**Consultation Response from Mike Hibbert,
KC Waste Strategy(Refuse & Recycling)**

2024/92236 Wood Street Mills, Wakefield Road, Scissett, Huddersfield, HD8 9JS

Demolition of existing industrial building and erection of storage and distribution building with car park and associated engineering works

Responding Ref: WPN 24-034

File Identifier	Project	Originator	Volume	Level	Type	Role	Number	Revision
PTWR - MWA - XX - XX - DR - A - 0005								P1

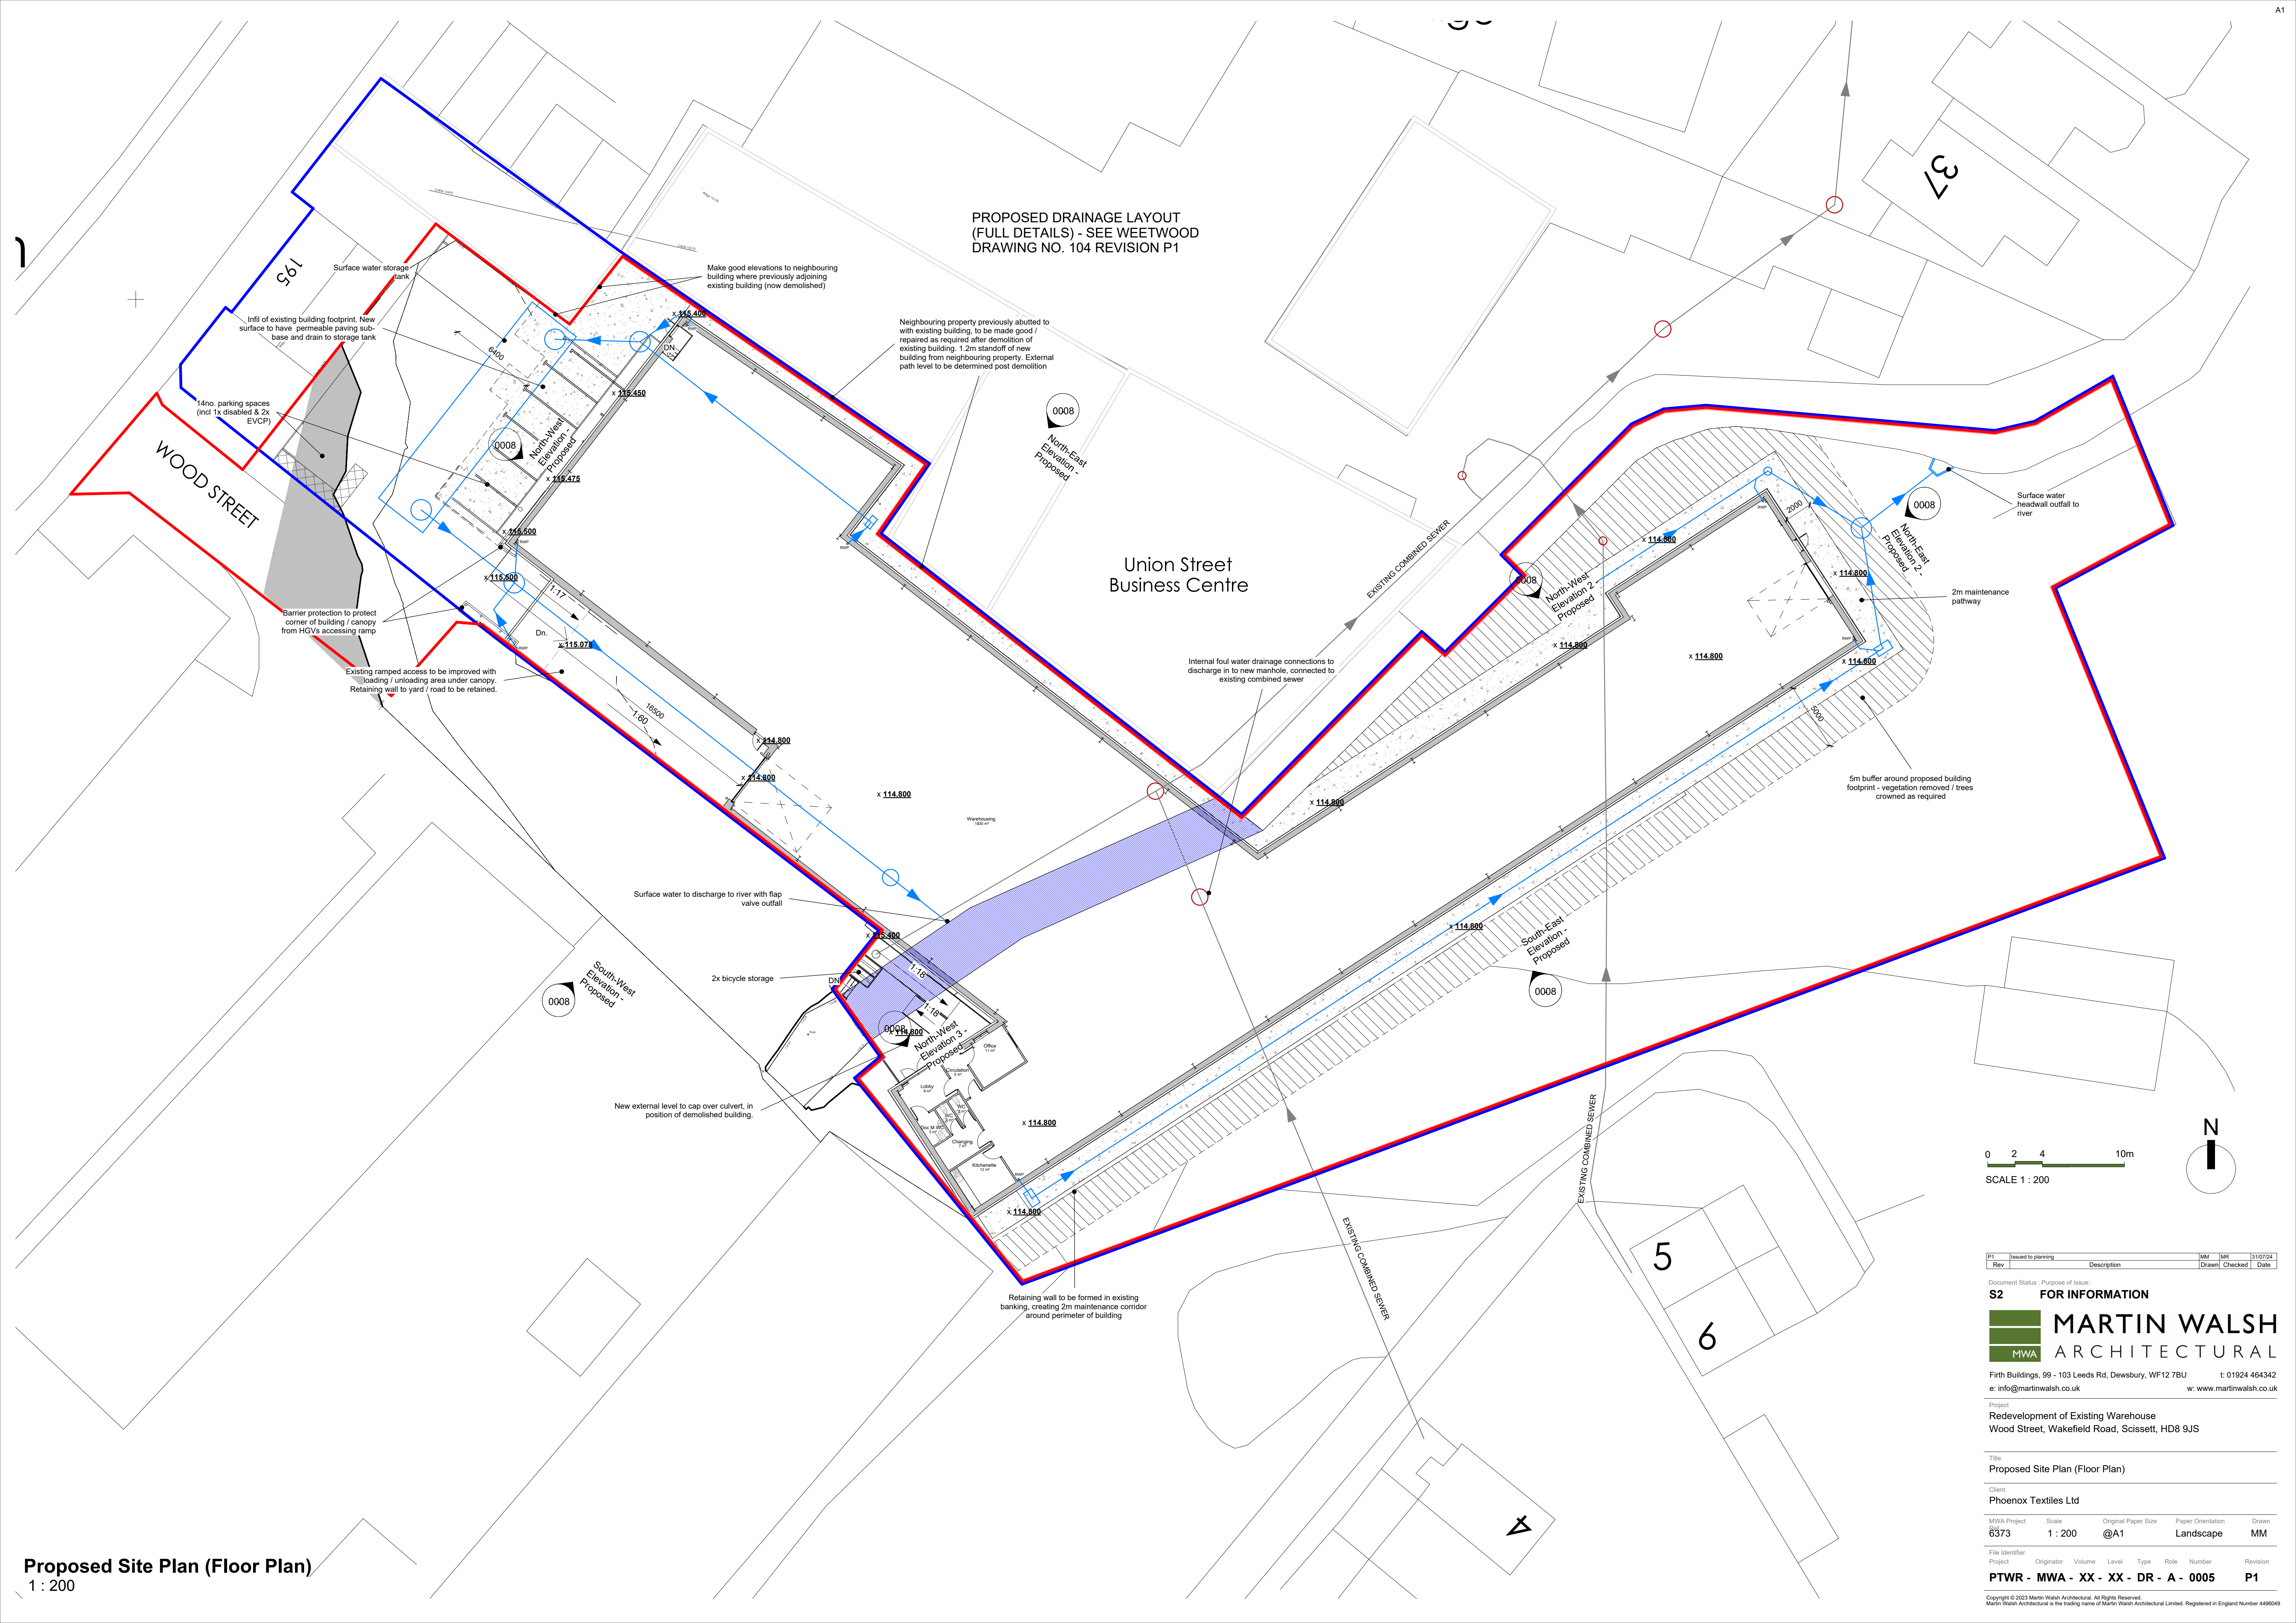
The applicant has submitted Proposed Site Plan (Floor Plan) PTWR - MWA - XX - XX - DR - A – 0005 Rev P1 dated 31/07/24. The application form states that the application does not include details of waste storage or recycling.

- With limited information included in the application, it is difficult to predict likely waste generation and therefore waste storage capacity required.

- As the applicant has existing warehouse and manufacturing buildings in Scissett waste arisings data should be available and there will be existing provision for waste generated at those sites. Any waste storage area should be secure to prevent theft, unauthorised use/ fly tipping, arson or rough sleeping.

- Waste storage presents a fire risk. Any skip/ wheeliebin storage location should be carefully considered when undertaking a fire risk assessment and may need relocating away from buildings.

- In line with Government's OUR WASTE, OUR RESOURCES: A STRATEGY FOR ENGLAND and the requirement for waste producers to comply with Regulation 12 of The Waste (England and Wales) Regulations 2011 there should be separate provision for recyclates and residual wastes. Waste storage should be identified on site either within the warehouse or on the service yard to accommodate general waste and packaging/ cardboard skips, etc.

- Any waste storage compounds should be large enough to accommodate the waste being stored and ensure skips are on an impermeable surface with sealed drainage to ensure avoidance of contamination of ground or surface water.
